A46 Newark Bypass

Scheme Number: TR010065

7.73 Comments on Submissions Received at Previous Deadline

Comments on Submissions Received at Previous Deadline

**Figure 3-3 Location of the Newark roundabout embankment**

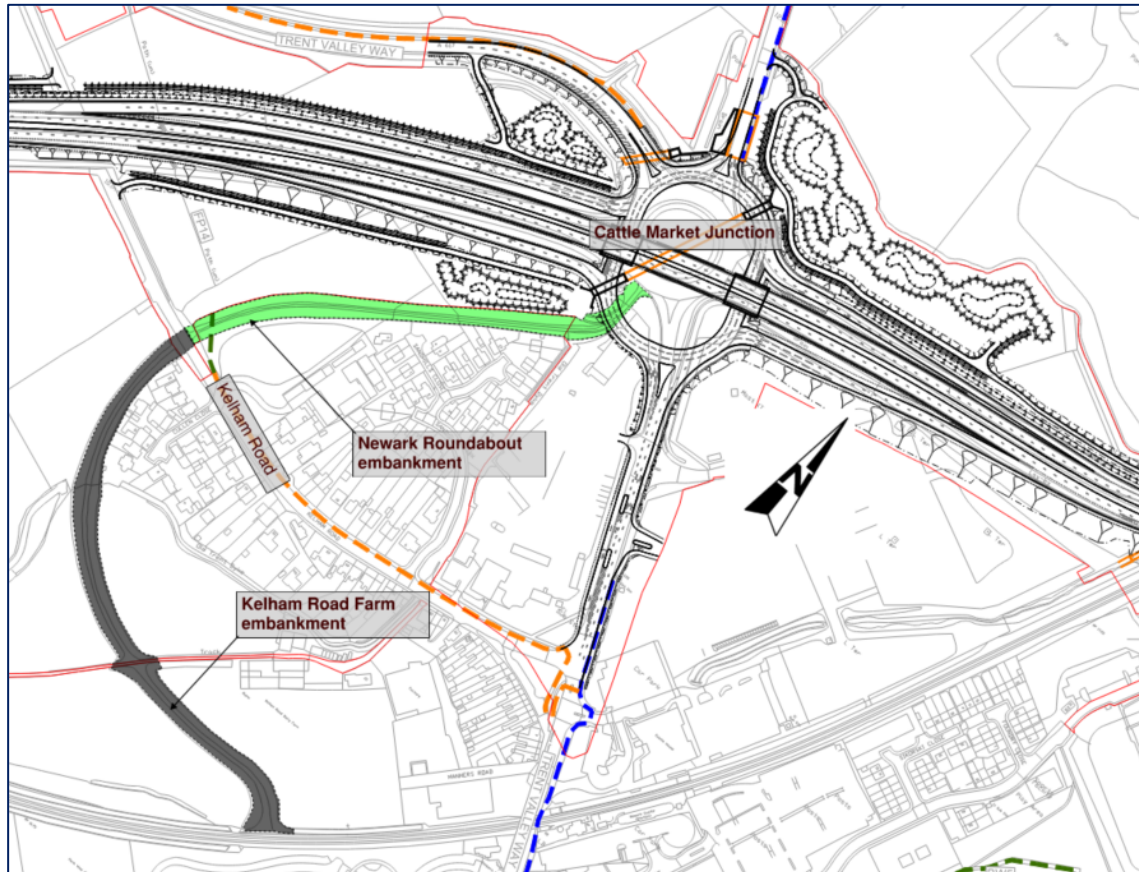
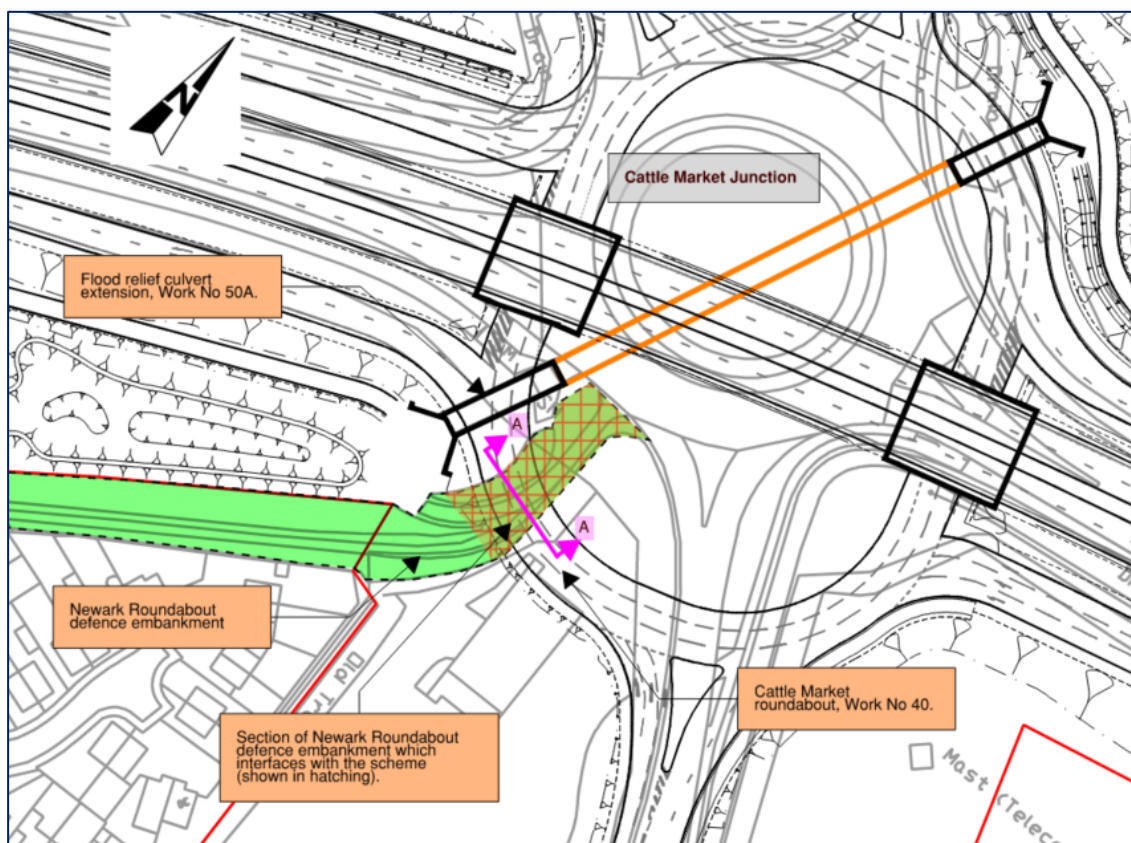
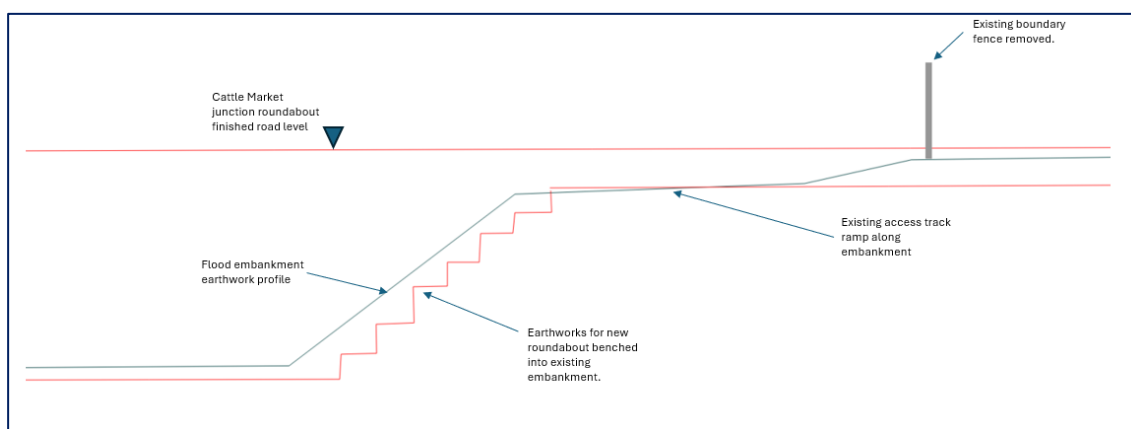
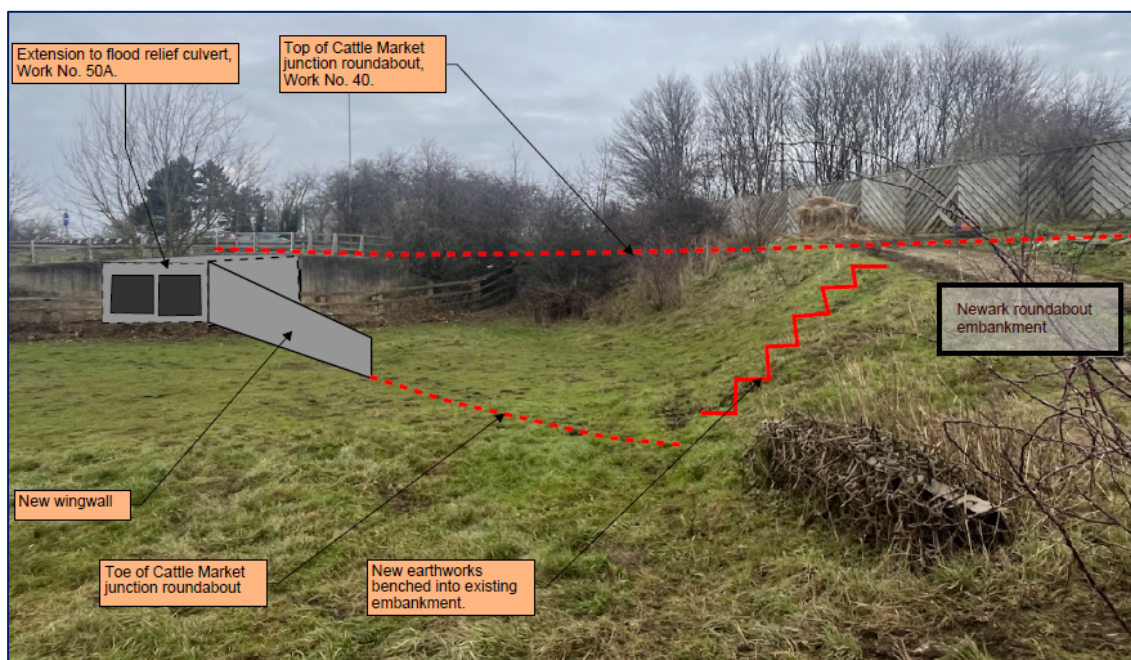
<div><div>Interaction with Environment Agency flood defences (EAFR-008)</div><div>Please see our comments above in relation to Cross sections requested by the Environment Agency - Rev 1 [REP5-063]. While we are satisfied in relation to the Cree's Lane flood defence embankment, further information is required in relation to the Newark Roundabout / Cattle Market flood defence embankment.</div><div>We are working with the Applicant to resolve this issue and ensure the required information is provided to satisfy our concerns.</div></div>	<div><div>The Applicant has provided further information in relation to the Newark Roundabout / Cattle Market flood defence embankment in its response to the Cross sections requested by the Environment Agency - Rev 1 [REP5-063] above. It is understood that these will be finalised at detailed design stage as part of the required Flood Risk Activity Permit. The additional information contained in the response to the Cross sections requested by the Environment Agency - Rev 1 [REP5-063] above has also been provided in the Deadline 7 update to the Cross Sections Requested by the Environment Agency. The updated information includes details of the cross section of the existing embankment, construction methodology and sequencing and confirmation that the works would be controlled through a Flood Risk Assessment Permit. Once this has been submitted at Deadline 7 of the Examination the Environment Agency have confirmed they will be able to consider this issue as Agreed.</div></div>

The Applicant has identified mitigation measures that could be adopted prior to, during and following the benching works to join the Scheme to the Newark Roundabout / Cattle market flood defence embankment. These would be secured through the Flood Risk Activity Permit that the Applicant will be required to obtain from the EA prior to the benching works commencing

Mitigation measures could include localised testing of the bund prior to excavation to confirm its integrity and undertaking the excavation works in stages to limit the length of exposed benching. In addition, the following construction methodology could be adopted

- i) Interface with embankments identified on the design hazard log and included in pre-construction information and health and safety file.
- ii) Install warning signs for the defence embankment.
- iii) Install boundary fencing along the Order Limits, along the toe of the defence embankment.
- iv) Site clearance. Removal of vegetation and existing fences.
- v) Excavate 0.5m by 0.5m benches into the west face of the flood defence embankment with a 360-degree tracked excavator.
